City of Portland, Maine - Building or Use Permit

Permit No:	05-0159	Date Applied For:	02/09/2005	CBL:	013 K028001
------------	---------	-------------------	------------	------	-------------

Proposed Use:	Proposed Project Description:
8 Unit Condominium	Build 8 unit Condominium

Date: March 23, 2005
 Project: Sumner Court
 117 Sheriden Street
 To: Mike Nugent
 From: David Tetreault
 Subject: Building Permit Application

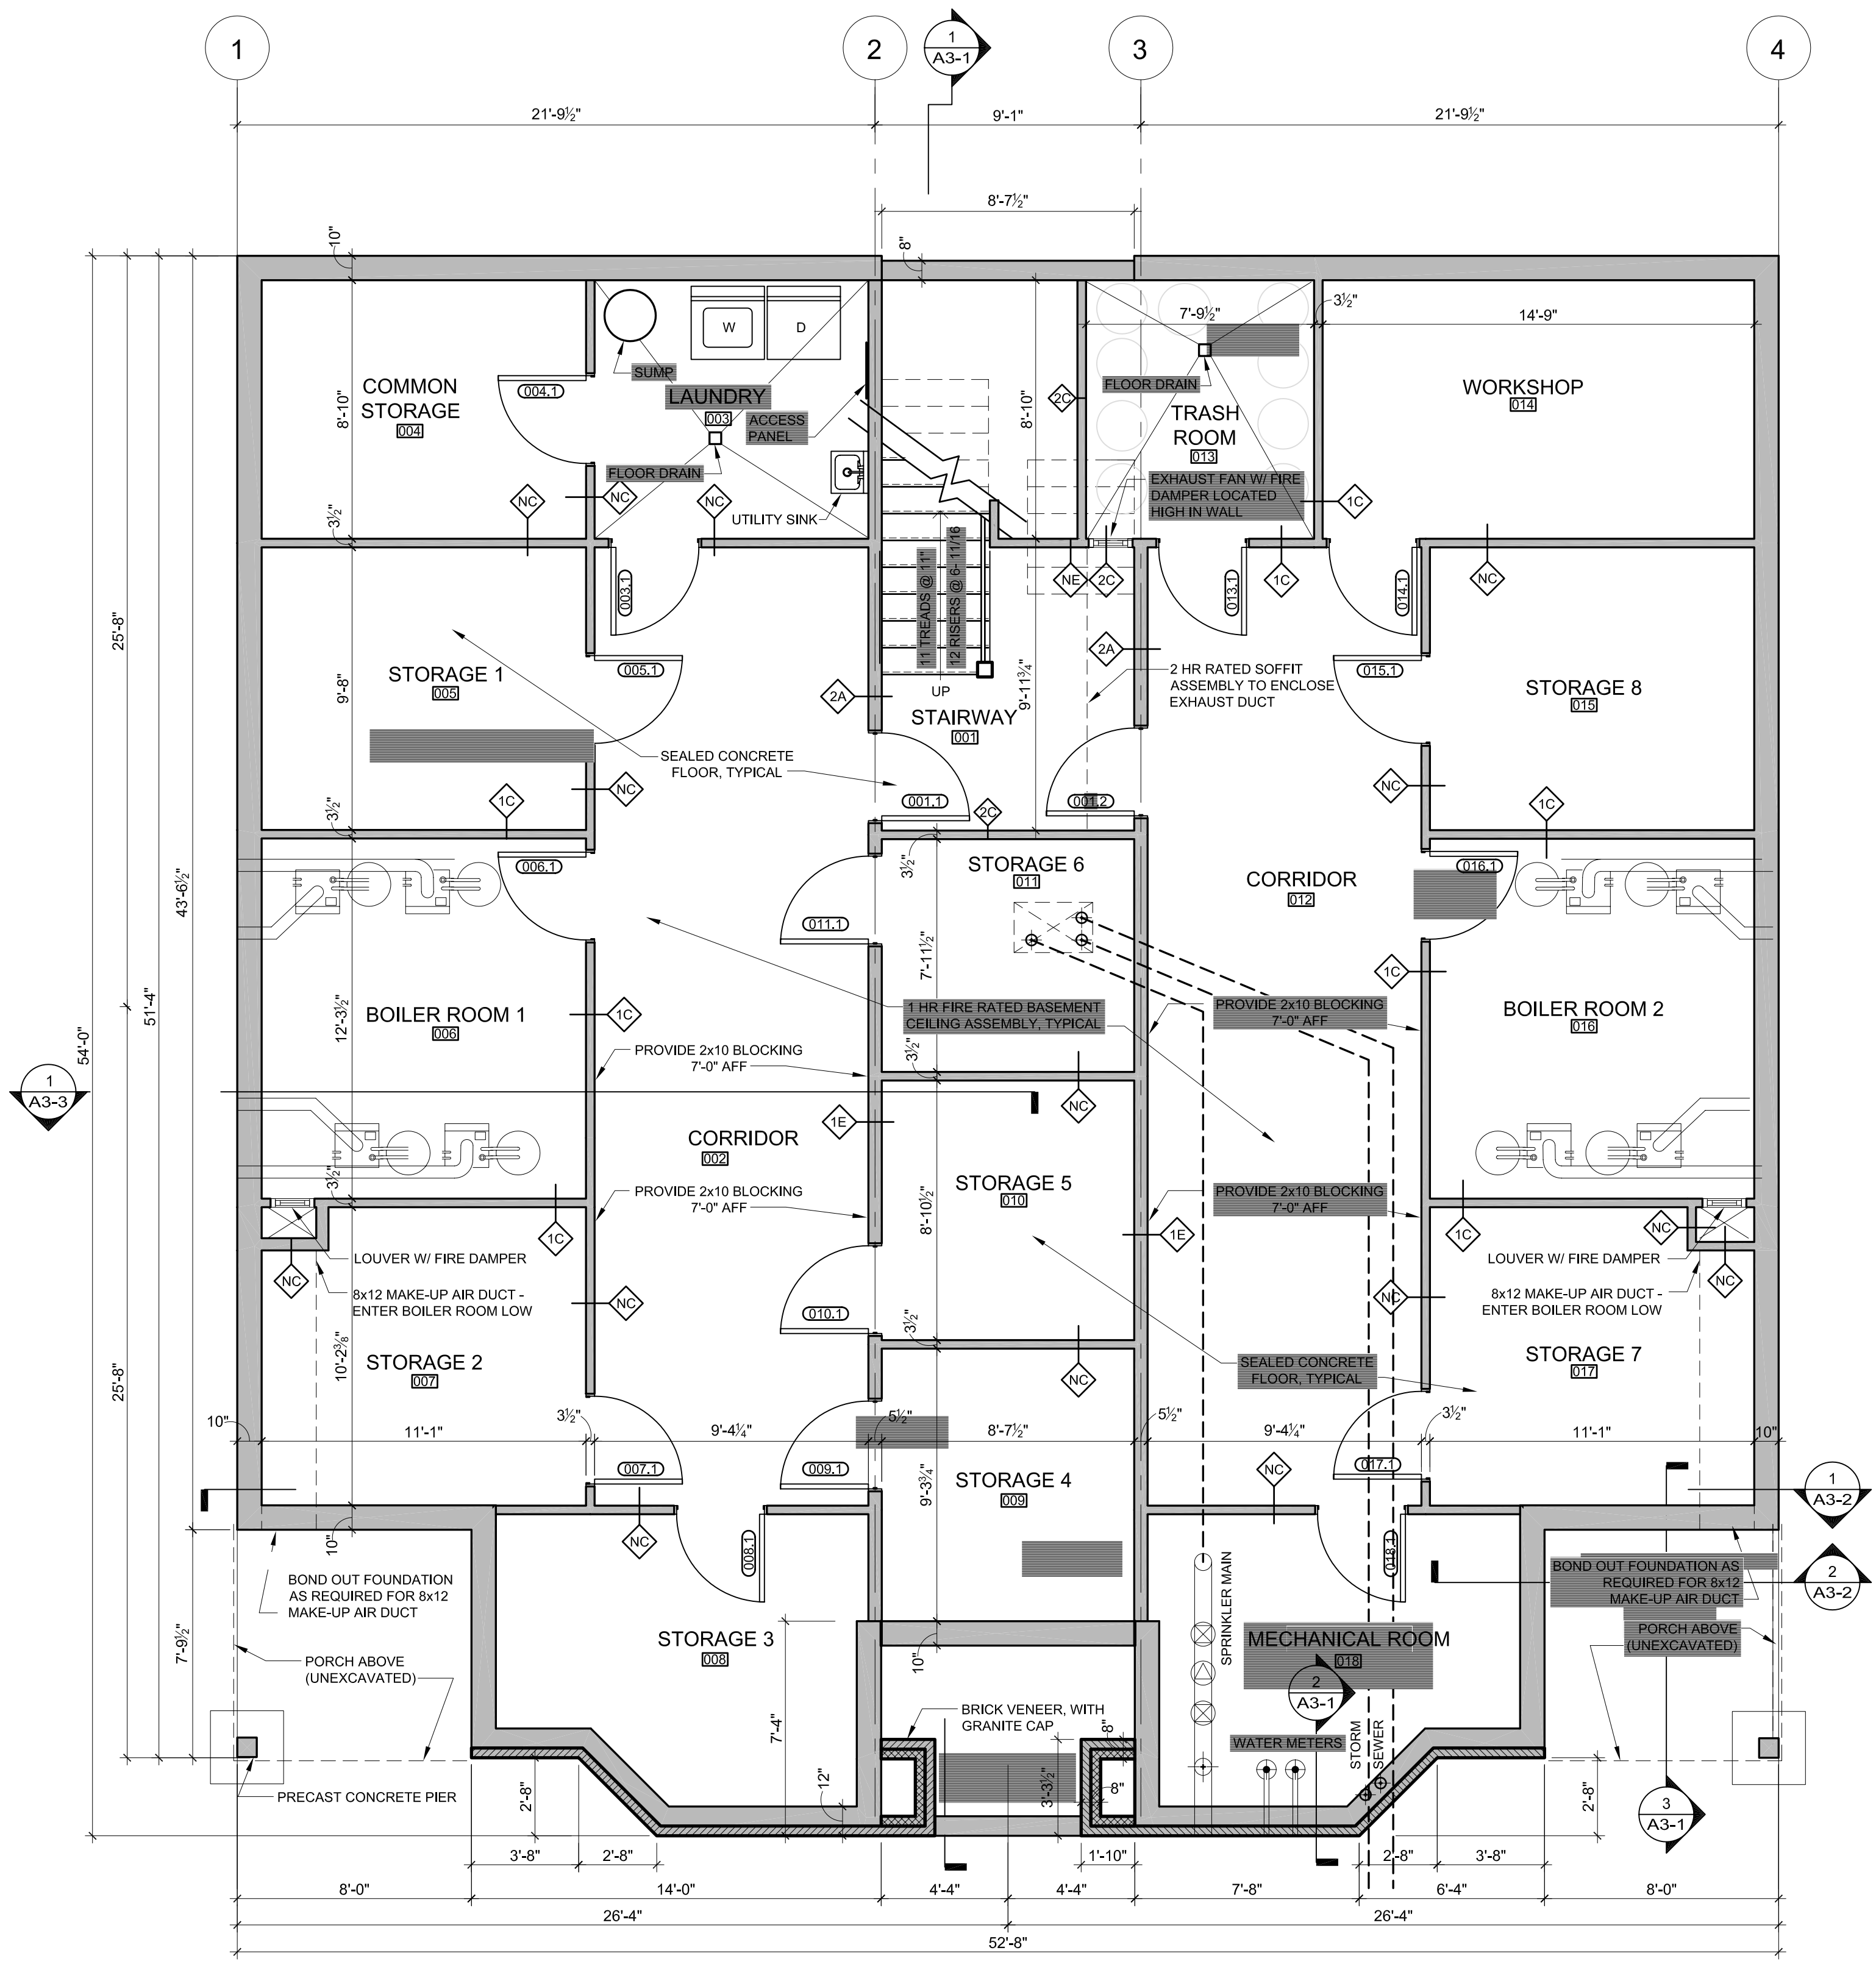
- 1) The discrepancy between the soils report and the interior footing design must be fixed and submitted for approval prior to forming this interior footings
- 2) Unprotected opening on the North face must comply with table 704.8
- 3) Guard rail shop drawings must be approved by the project engineer prior to installation.
- 4) Specific items used to protect penetrations in fire separation assemblies must be approved prior to installation.
- 5) The Statement of Special Inspections Dated 3/23/05 must be signed and returned prior to commencement of construction.

In our report on subsurface and foundation investigation dated November 10, 2004, we recommended that interior footings be founded a minimum of 1.5 feet below the ground floor slab at an allowable bearing stress of 3,000 pounds per square foot (psf). That recommendation was made prior to the structural engineer finalizing framing and building loads. The final design for the interior bearing walls detailed support on a 2-foot wide by 8-inch thickened slab bearing at 1,520 psf.

In our opinion, support on a thickened slab is acceptable because the applied stress is only 50 percent of the allowable bearing stress. The original recommendation anticipated a higher applied bearing stress, and therefore included an embedment of 1.5 feet. At the lower applied stress, embedment is not required.

The depth requirement stated in the Geotechnical report is used to isolate interior footings from the slab-on-grade. Bearing capacity is not affected at the higher elevation. Additional control joints will be cut parallel to both sides of the thickened slab to
